APPLICATION NAME: BOWDENS SILVER MINE AMENDMENT  
APPLICATION NUMBER: SSD5765  
**POWERLINE RE-ALIGNMENT BY GHD ...NO SETOUT PLAN**

APPLICATION NAME: BOWDENS SILVER MINE AMENDMENT  
APPLICATION NUMBER: SSD5765  
**LIMITED ANALYSIS OF VISUAL IMPACTS**

Figure A7.1 | Final Land Uses

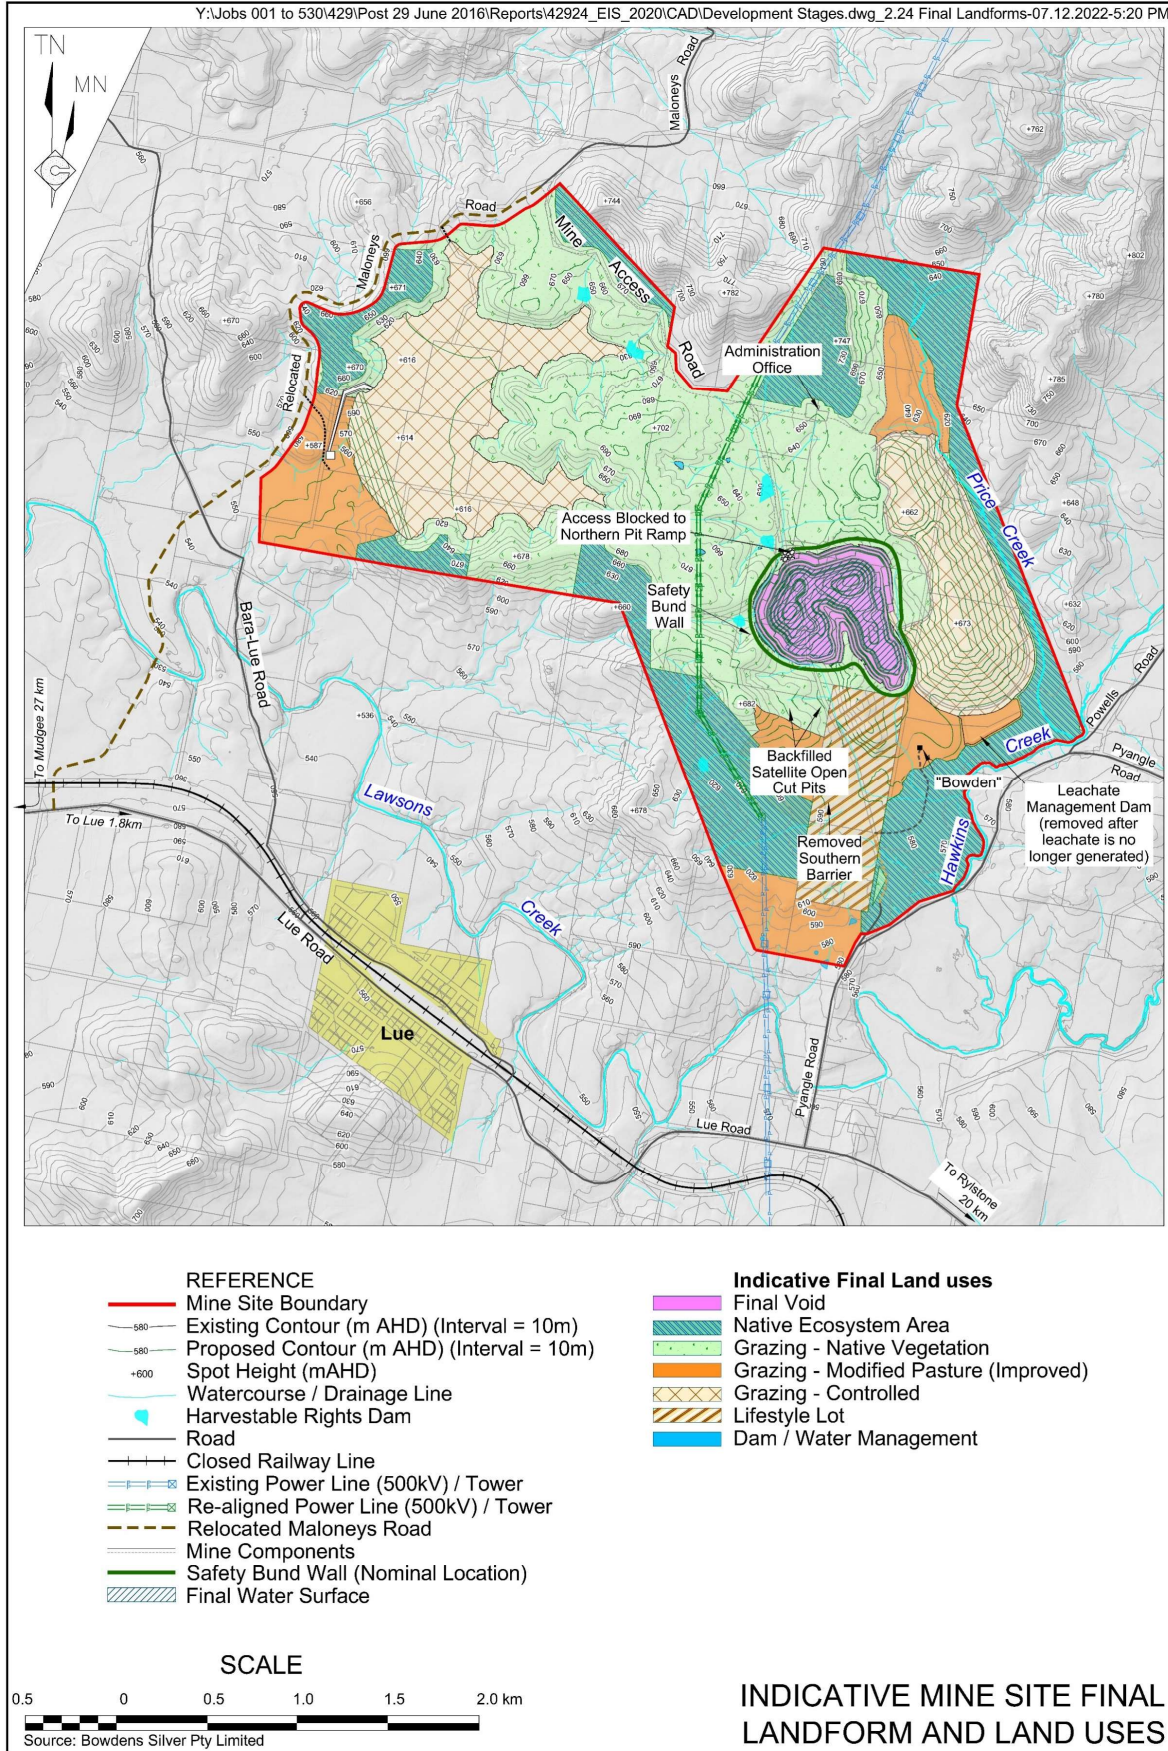
It is proposed by Bowdens not to be filled. Bowdens doesn't offer a cogent reason for not placing part of the WRE into it. Nor do they provide a case for not manipulating the walls (benching) to make it safer and for some level of access.

It remains on their maps untouched by their coloured pencils. Why?

Figure 4 : Proposed alignment plan view.

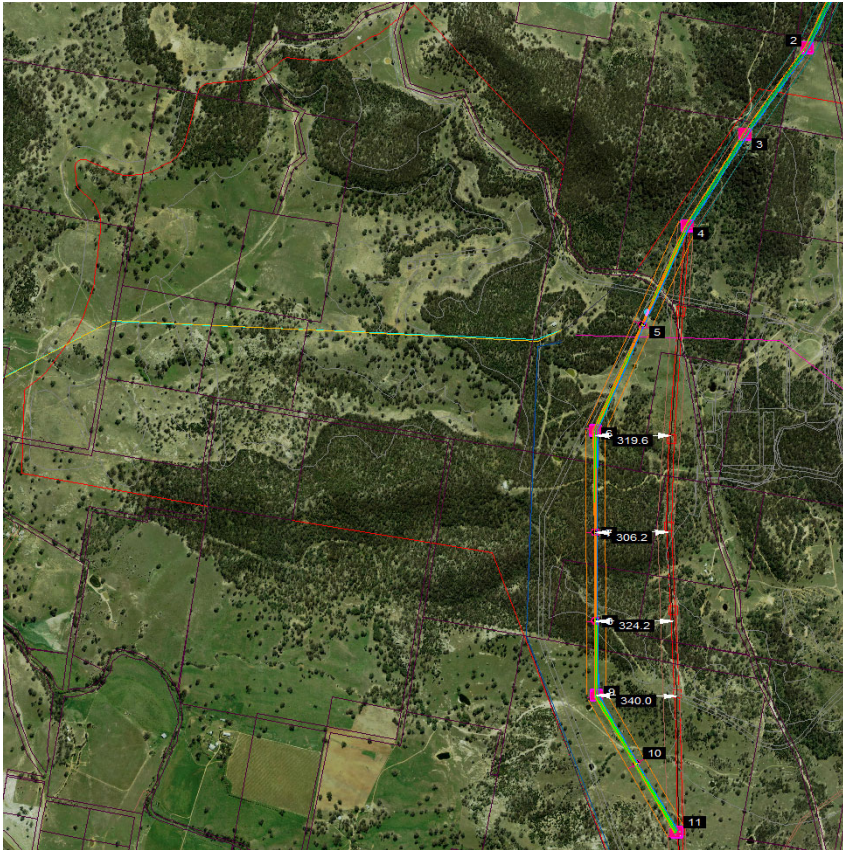
GHD one of the biggest and most famous engineering consultancies have dropped the ball. All that they show and call a 'plan' is a portion of an air photo with a few lines across it. There is no scale, not even a North point. It's been called plan view but it's not a plan it's a marked-up photo. It's a lopsided presentation, the relocated line and subject of the 'plan' is located off centre in any case.

The lack of scale and any other reference point that it is IMPOSSIBLE TO KNOW WHERE THE PROPOSED POWERLINE IS !

The point of this exercise and a lot of administrative etc time is to approve a new route. It has not been defined so we don't know where it is. Thanks GHD.

A simple diagram such as below would describe it. (centre line of the existing conductors, a start point at the Lue Road property line and a few measurements and deviation angles).
